From: 
Sent: 19 February 2014 17:12
To: Janice Chapman
Cc: Phil Wiltshire
Subject: RE: EG/1/14/ - Wanley Lodge, Wanleys Lane, Eastergate
Attachments: 101-09-Planning-Wanley Lodge car port - 2013-PL-02_RevB.pdf

DRAWN: POW	JOB NO: 101/09	SCALE: 1:50, 1:10 1:200, 1:1250 @
CHECKED: POW	DRAWING NO: PL-02	REV: A
DATE: Dec 13

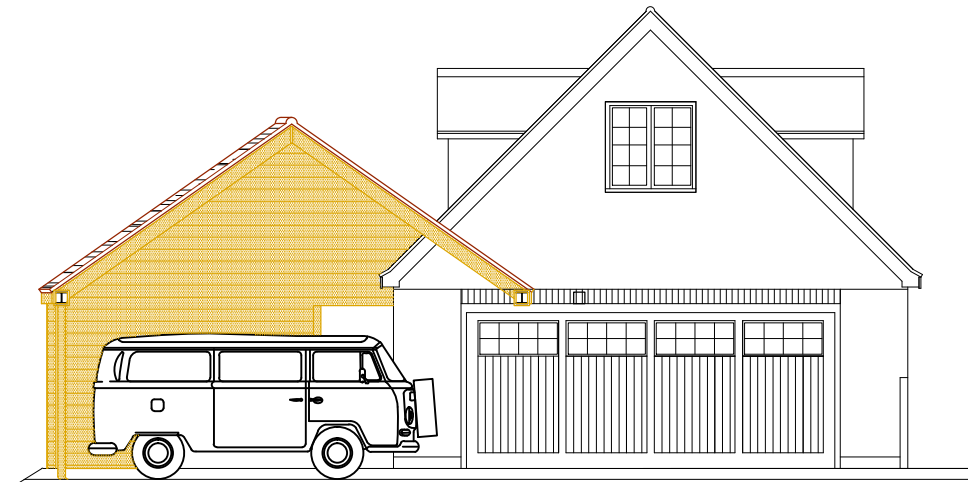
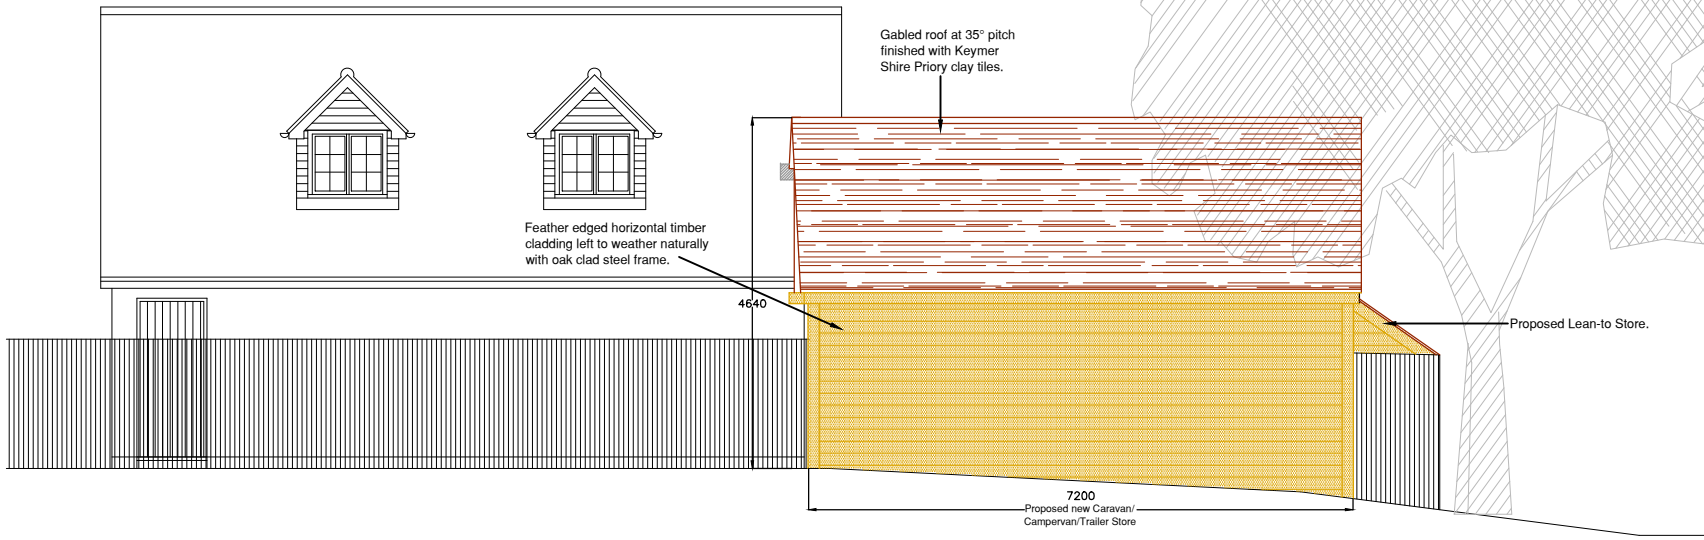
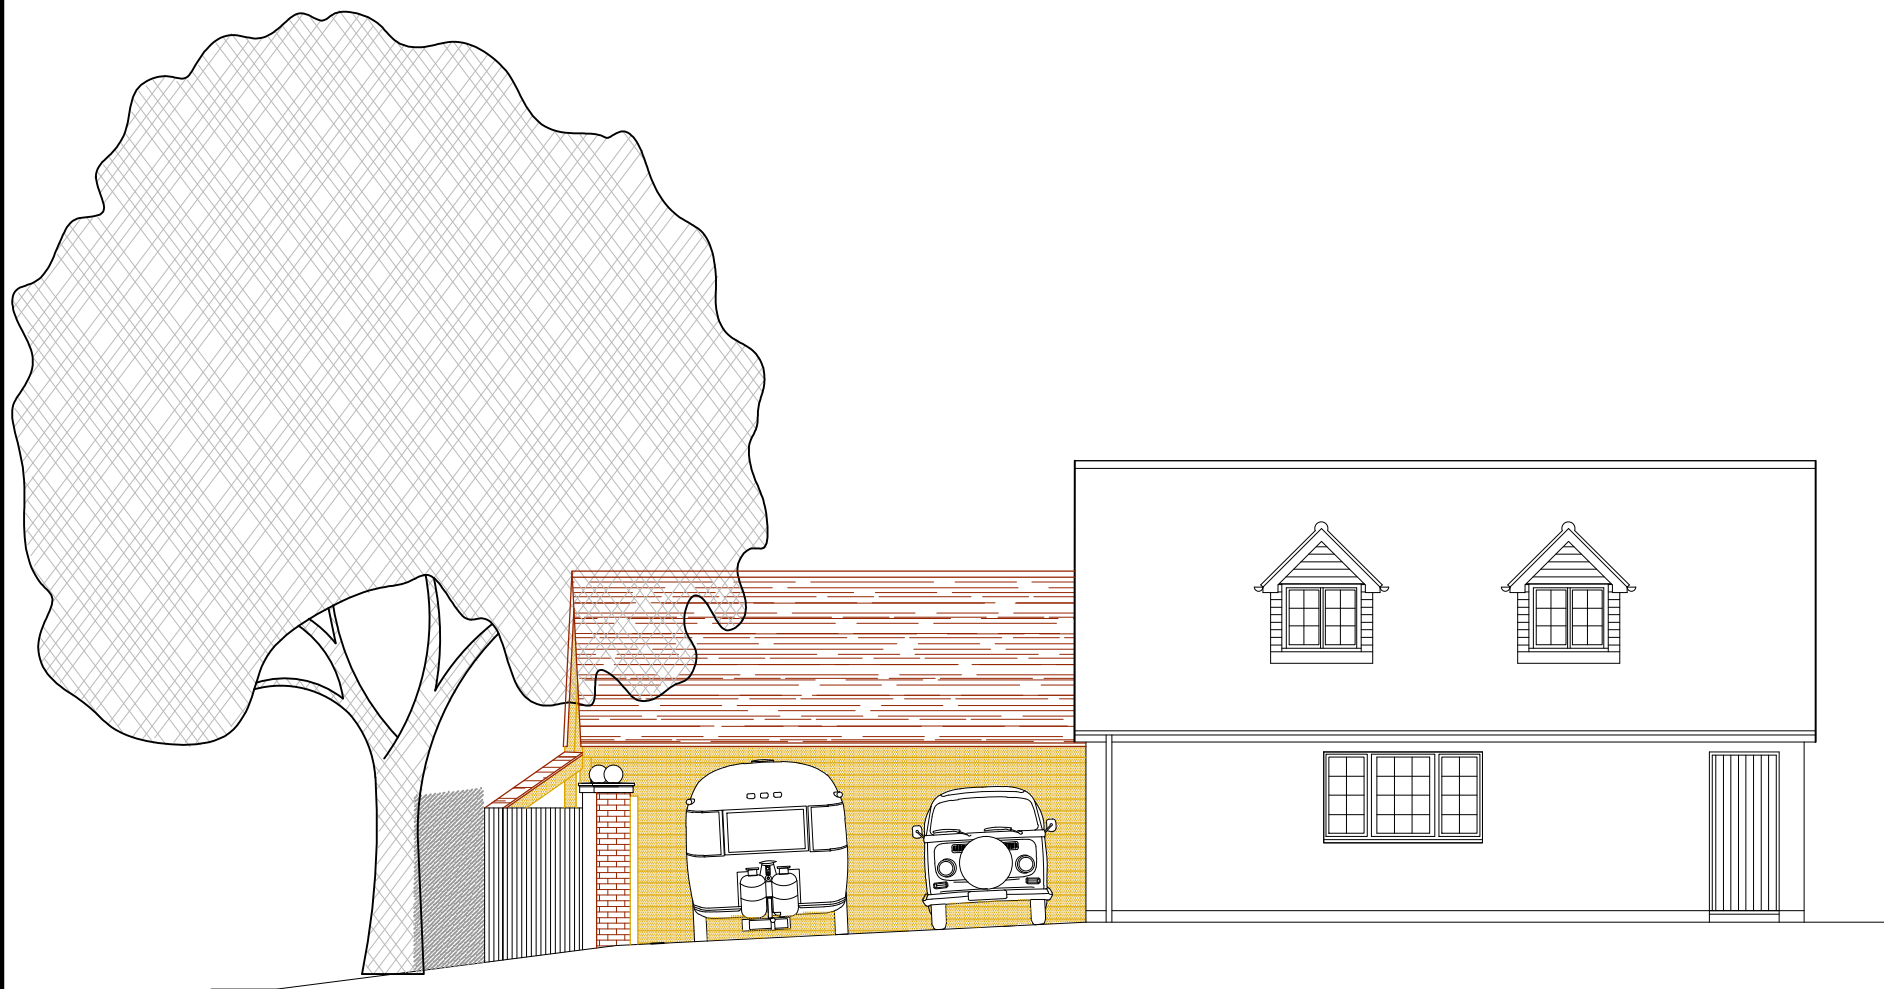
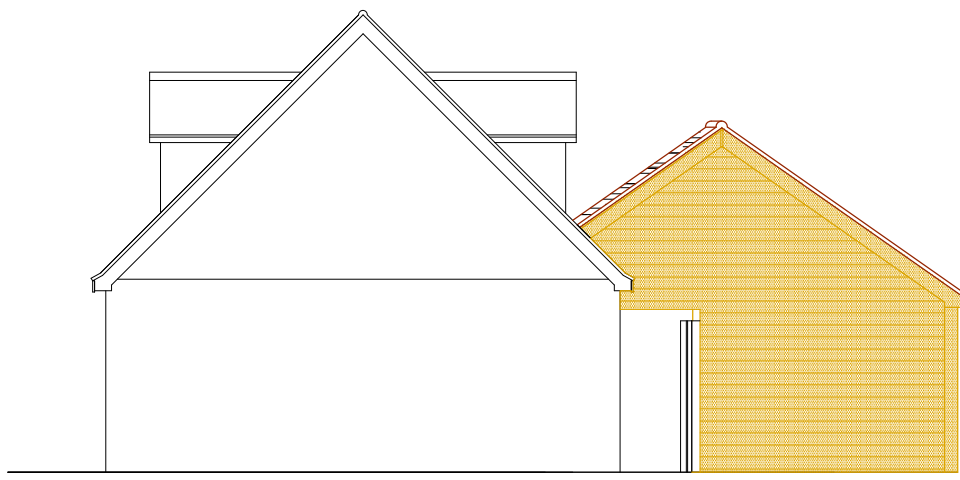
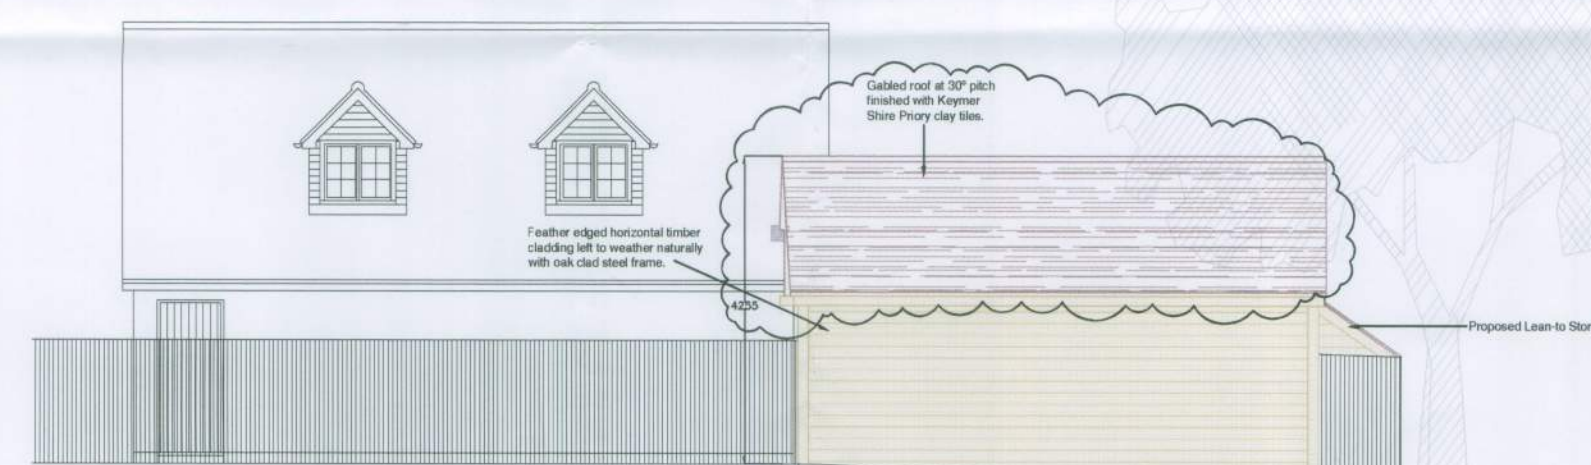
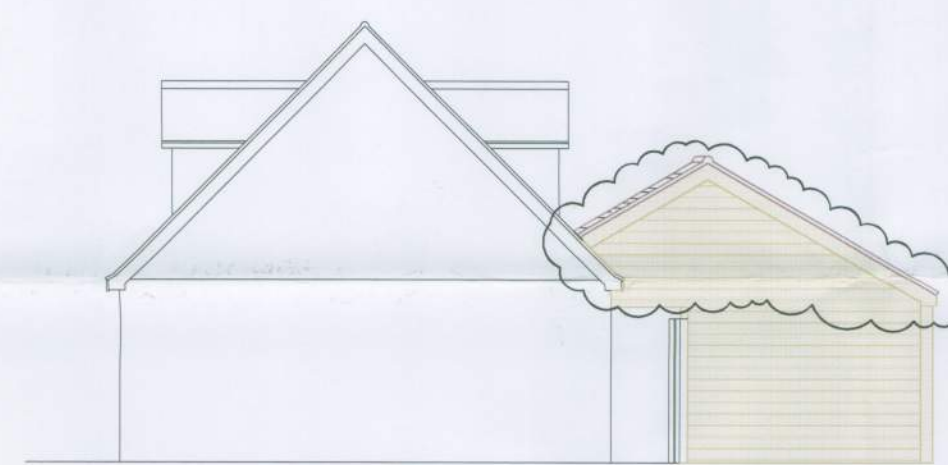
Please see attached revised drawings (RevB) showing the reduction of the previous proposal drawings (RevA) roof pitch from 35 degrees to 30 degrees thus giving a ridge reduction of 385mm.

Further to our conversion on this matter we feel the roof pitch has been reduced its maximum amount noting that it now falls under the tile manufacturers recommended minimum pitch of 35 degrees. Any further reduction in pitch would affect the waterproofing integrity of the roof finish.
